DRB Application No.: **05DRB-01283 (P&F)**

Project # **1003982**

Project Name: **LANDS OF TAIHI & MARYANN JONES**

DEVELOPMENT REVIEW BOARD – SPEED MEMO

PURPOSE OF PLAT:

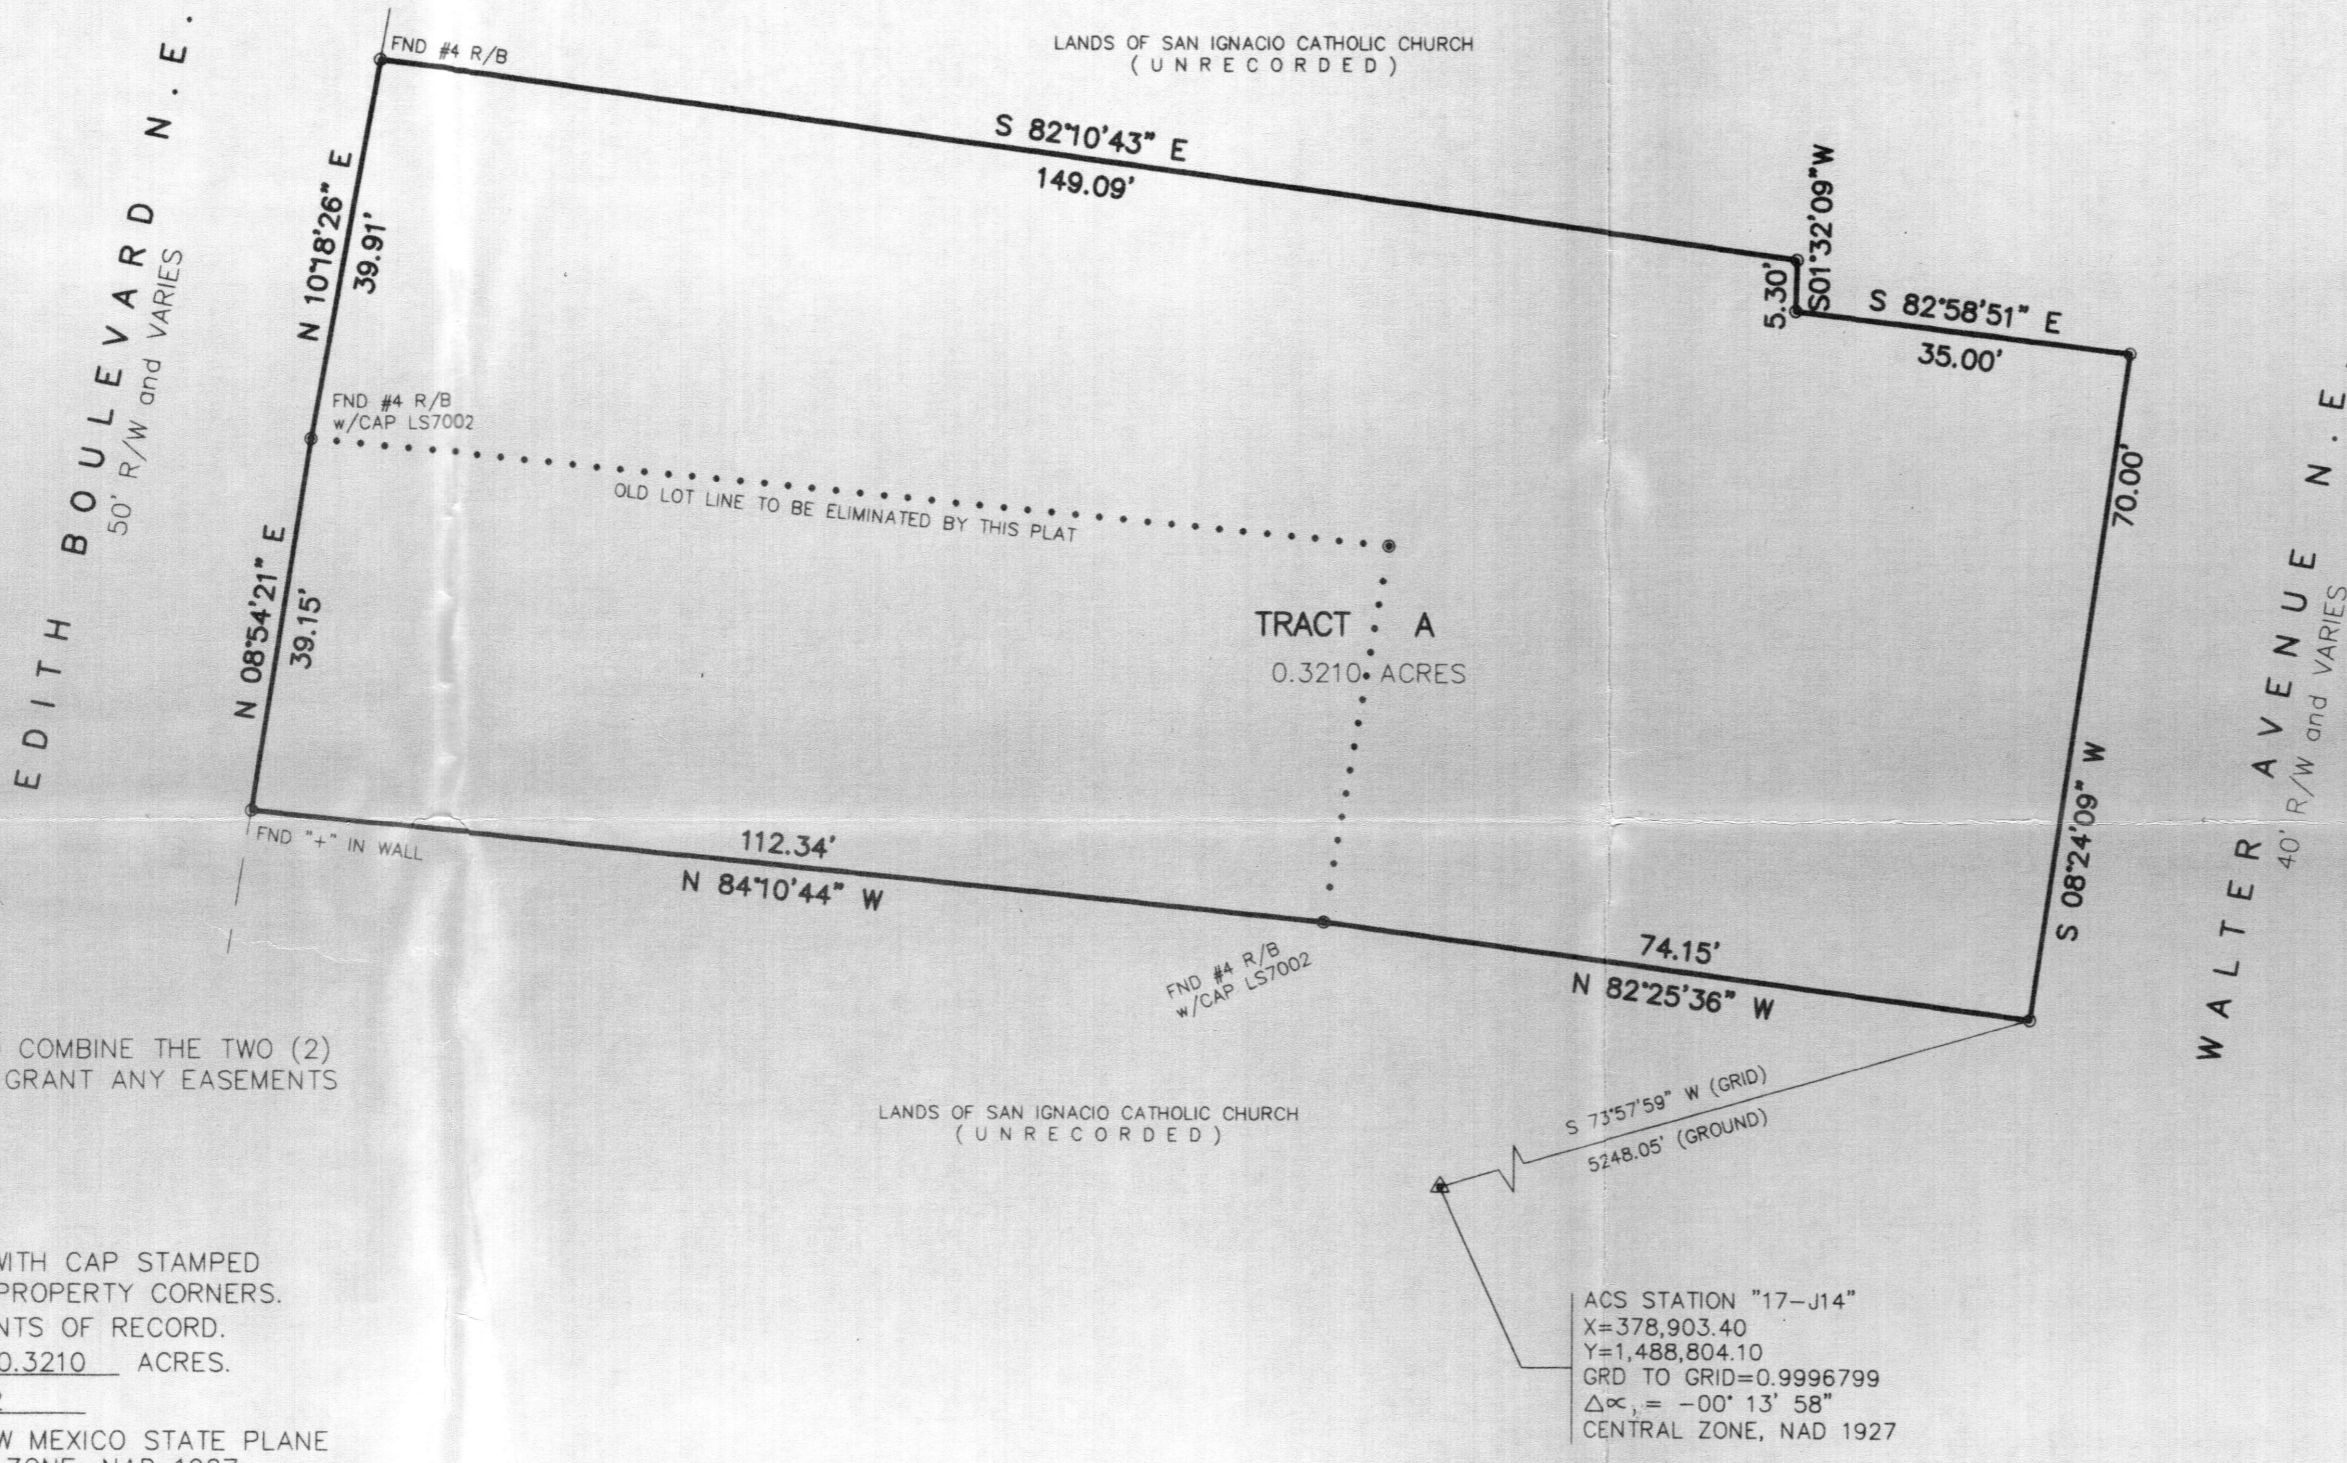
<u>No.</u>	<u>Comment</u>
1)	Need to provide sketch showing relationship of right-of-way, curb face and sidewalk location.
2)	Are the sidewalks in place?
3)	What are the right-of-way widths?
4)	Standard infrastructure per DPM required.

There appears to be an existing structure on one of the lots.

Are you going to remove the existing structure?
